Application Ref:	3/2018/0837	 Ribble Valley Borough Council www.ribblevalley.gov.uk
Date Inspected:	3/10/18	
Officer:	LG	
DELEGATED ITEM FILE REPORT:		APPROVAL

Development Description:	Development of former waste recycling centre to create 4 class B1/B8 business units
Site Address/Location:	Former Household Waste Recycling Centre, off Whalley Rd, Langho

Section A-A

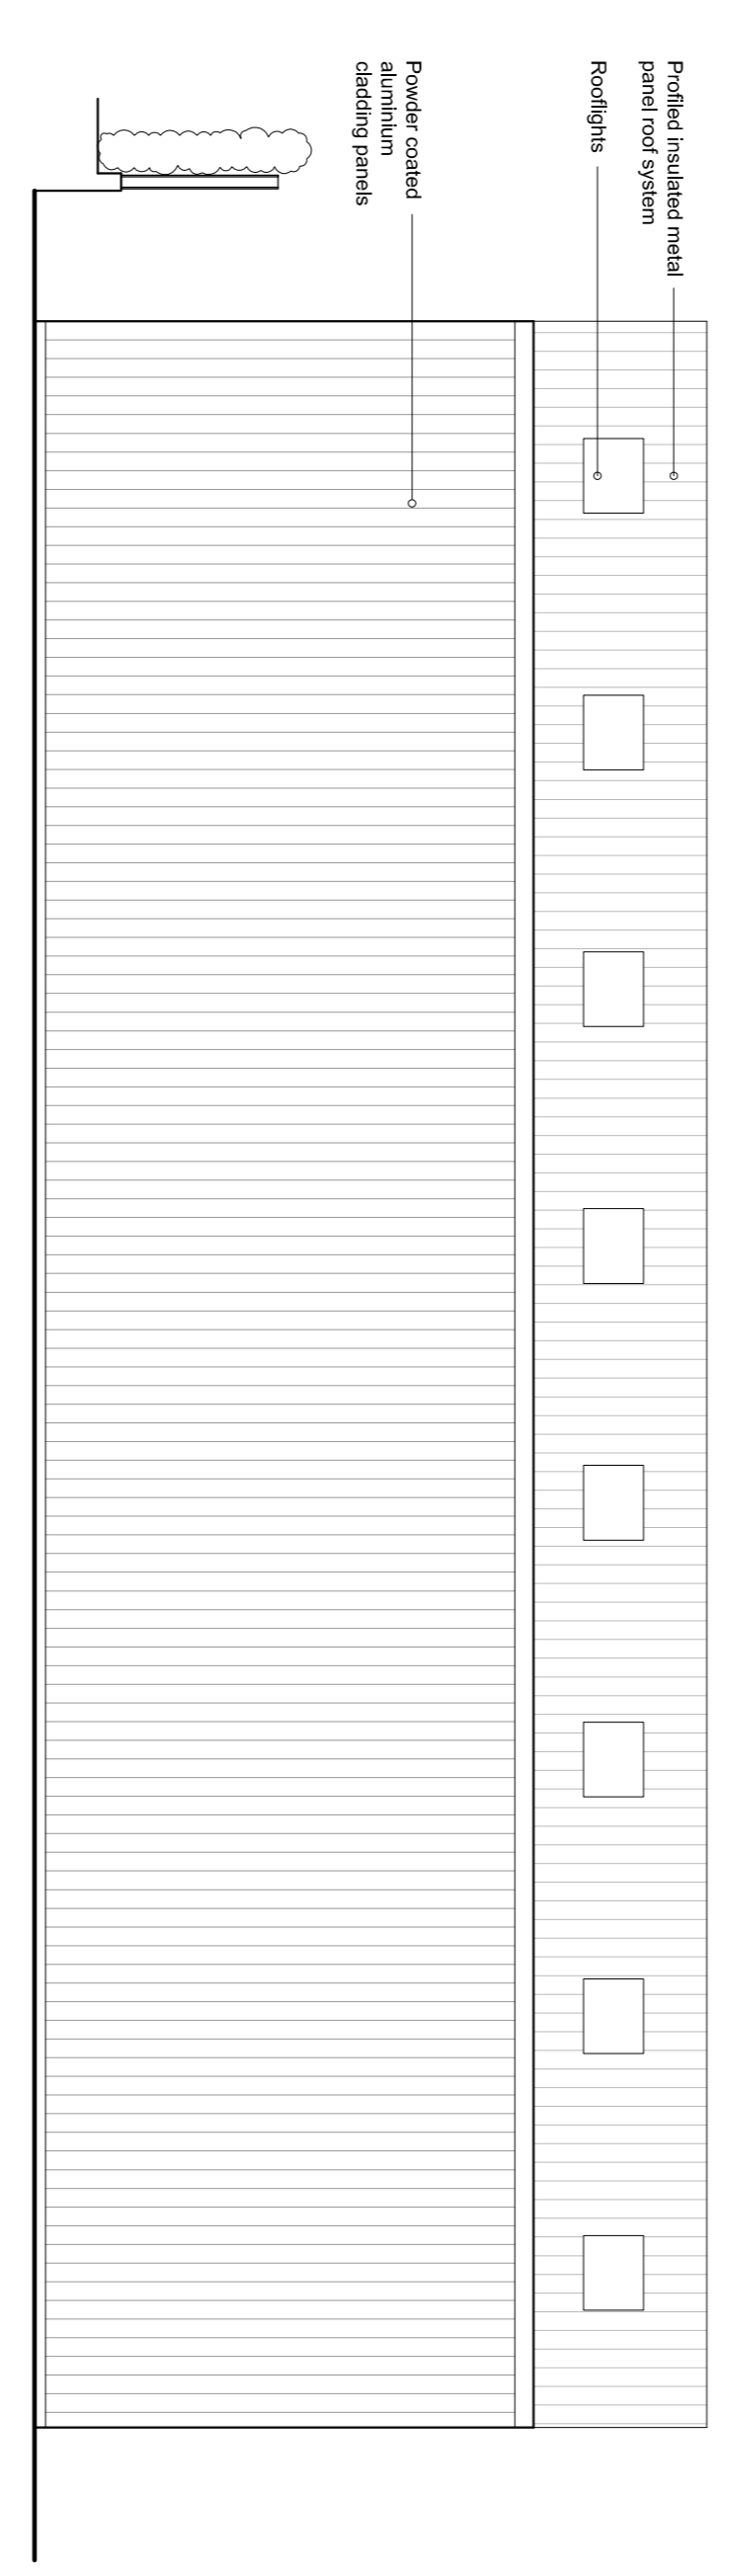
The proposed drawings (5625-10 C – Section A-A) show the development in the context of the adjacent apartment block and its windows. Accounting for the lowered eaves level at the rear and separation between the sites, it is not considered that the development would have an unacceptably overbearing impact for those adjacent occupants. The orientation of the respective buildings also helps to reduce any possible amenity loss, owing to the oblique angle between windows and the new structure.

Drawing Title  
**Proposed Site Plan and Longsight Road**

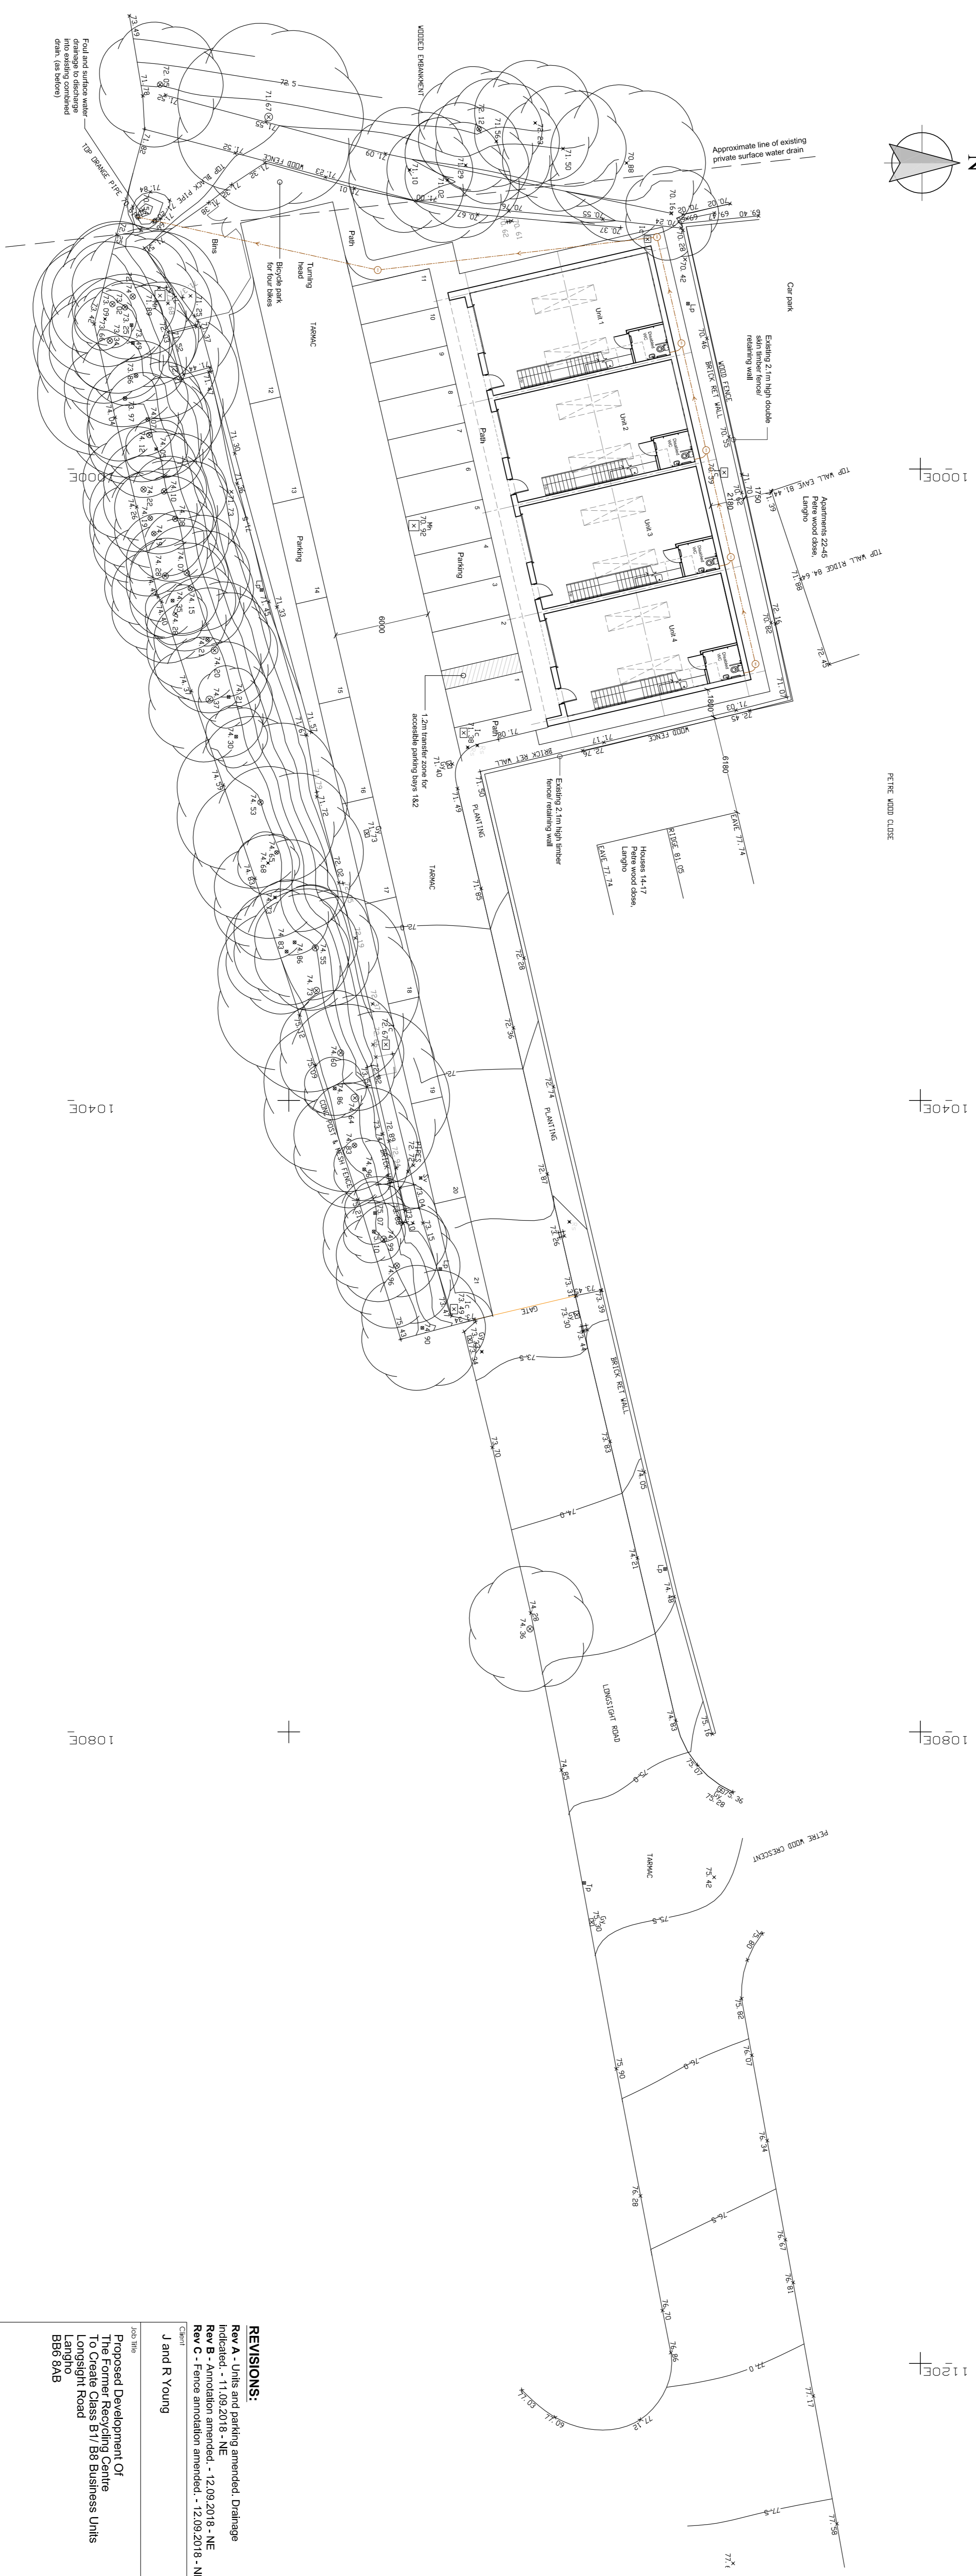
Lancashire County Council Highway Engineers have raised no objection to the proposal, following the submission of an amended site layout which demonstrated the necessary swept paths for larger vehicles to turn within the site and leave in forward gear. At their request the pedestrian footway is also to be extended into the site, providing direct access to the new building.
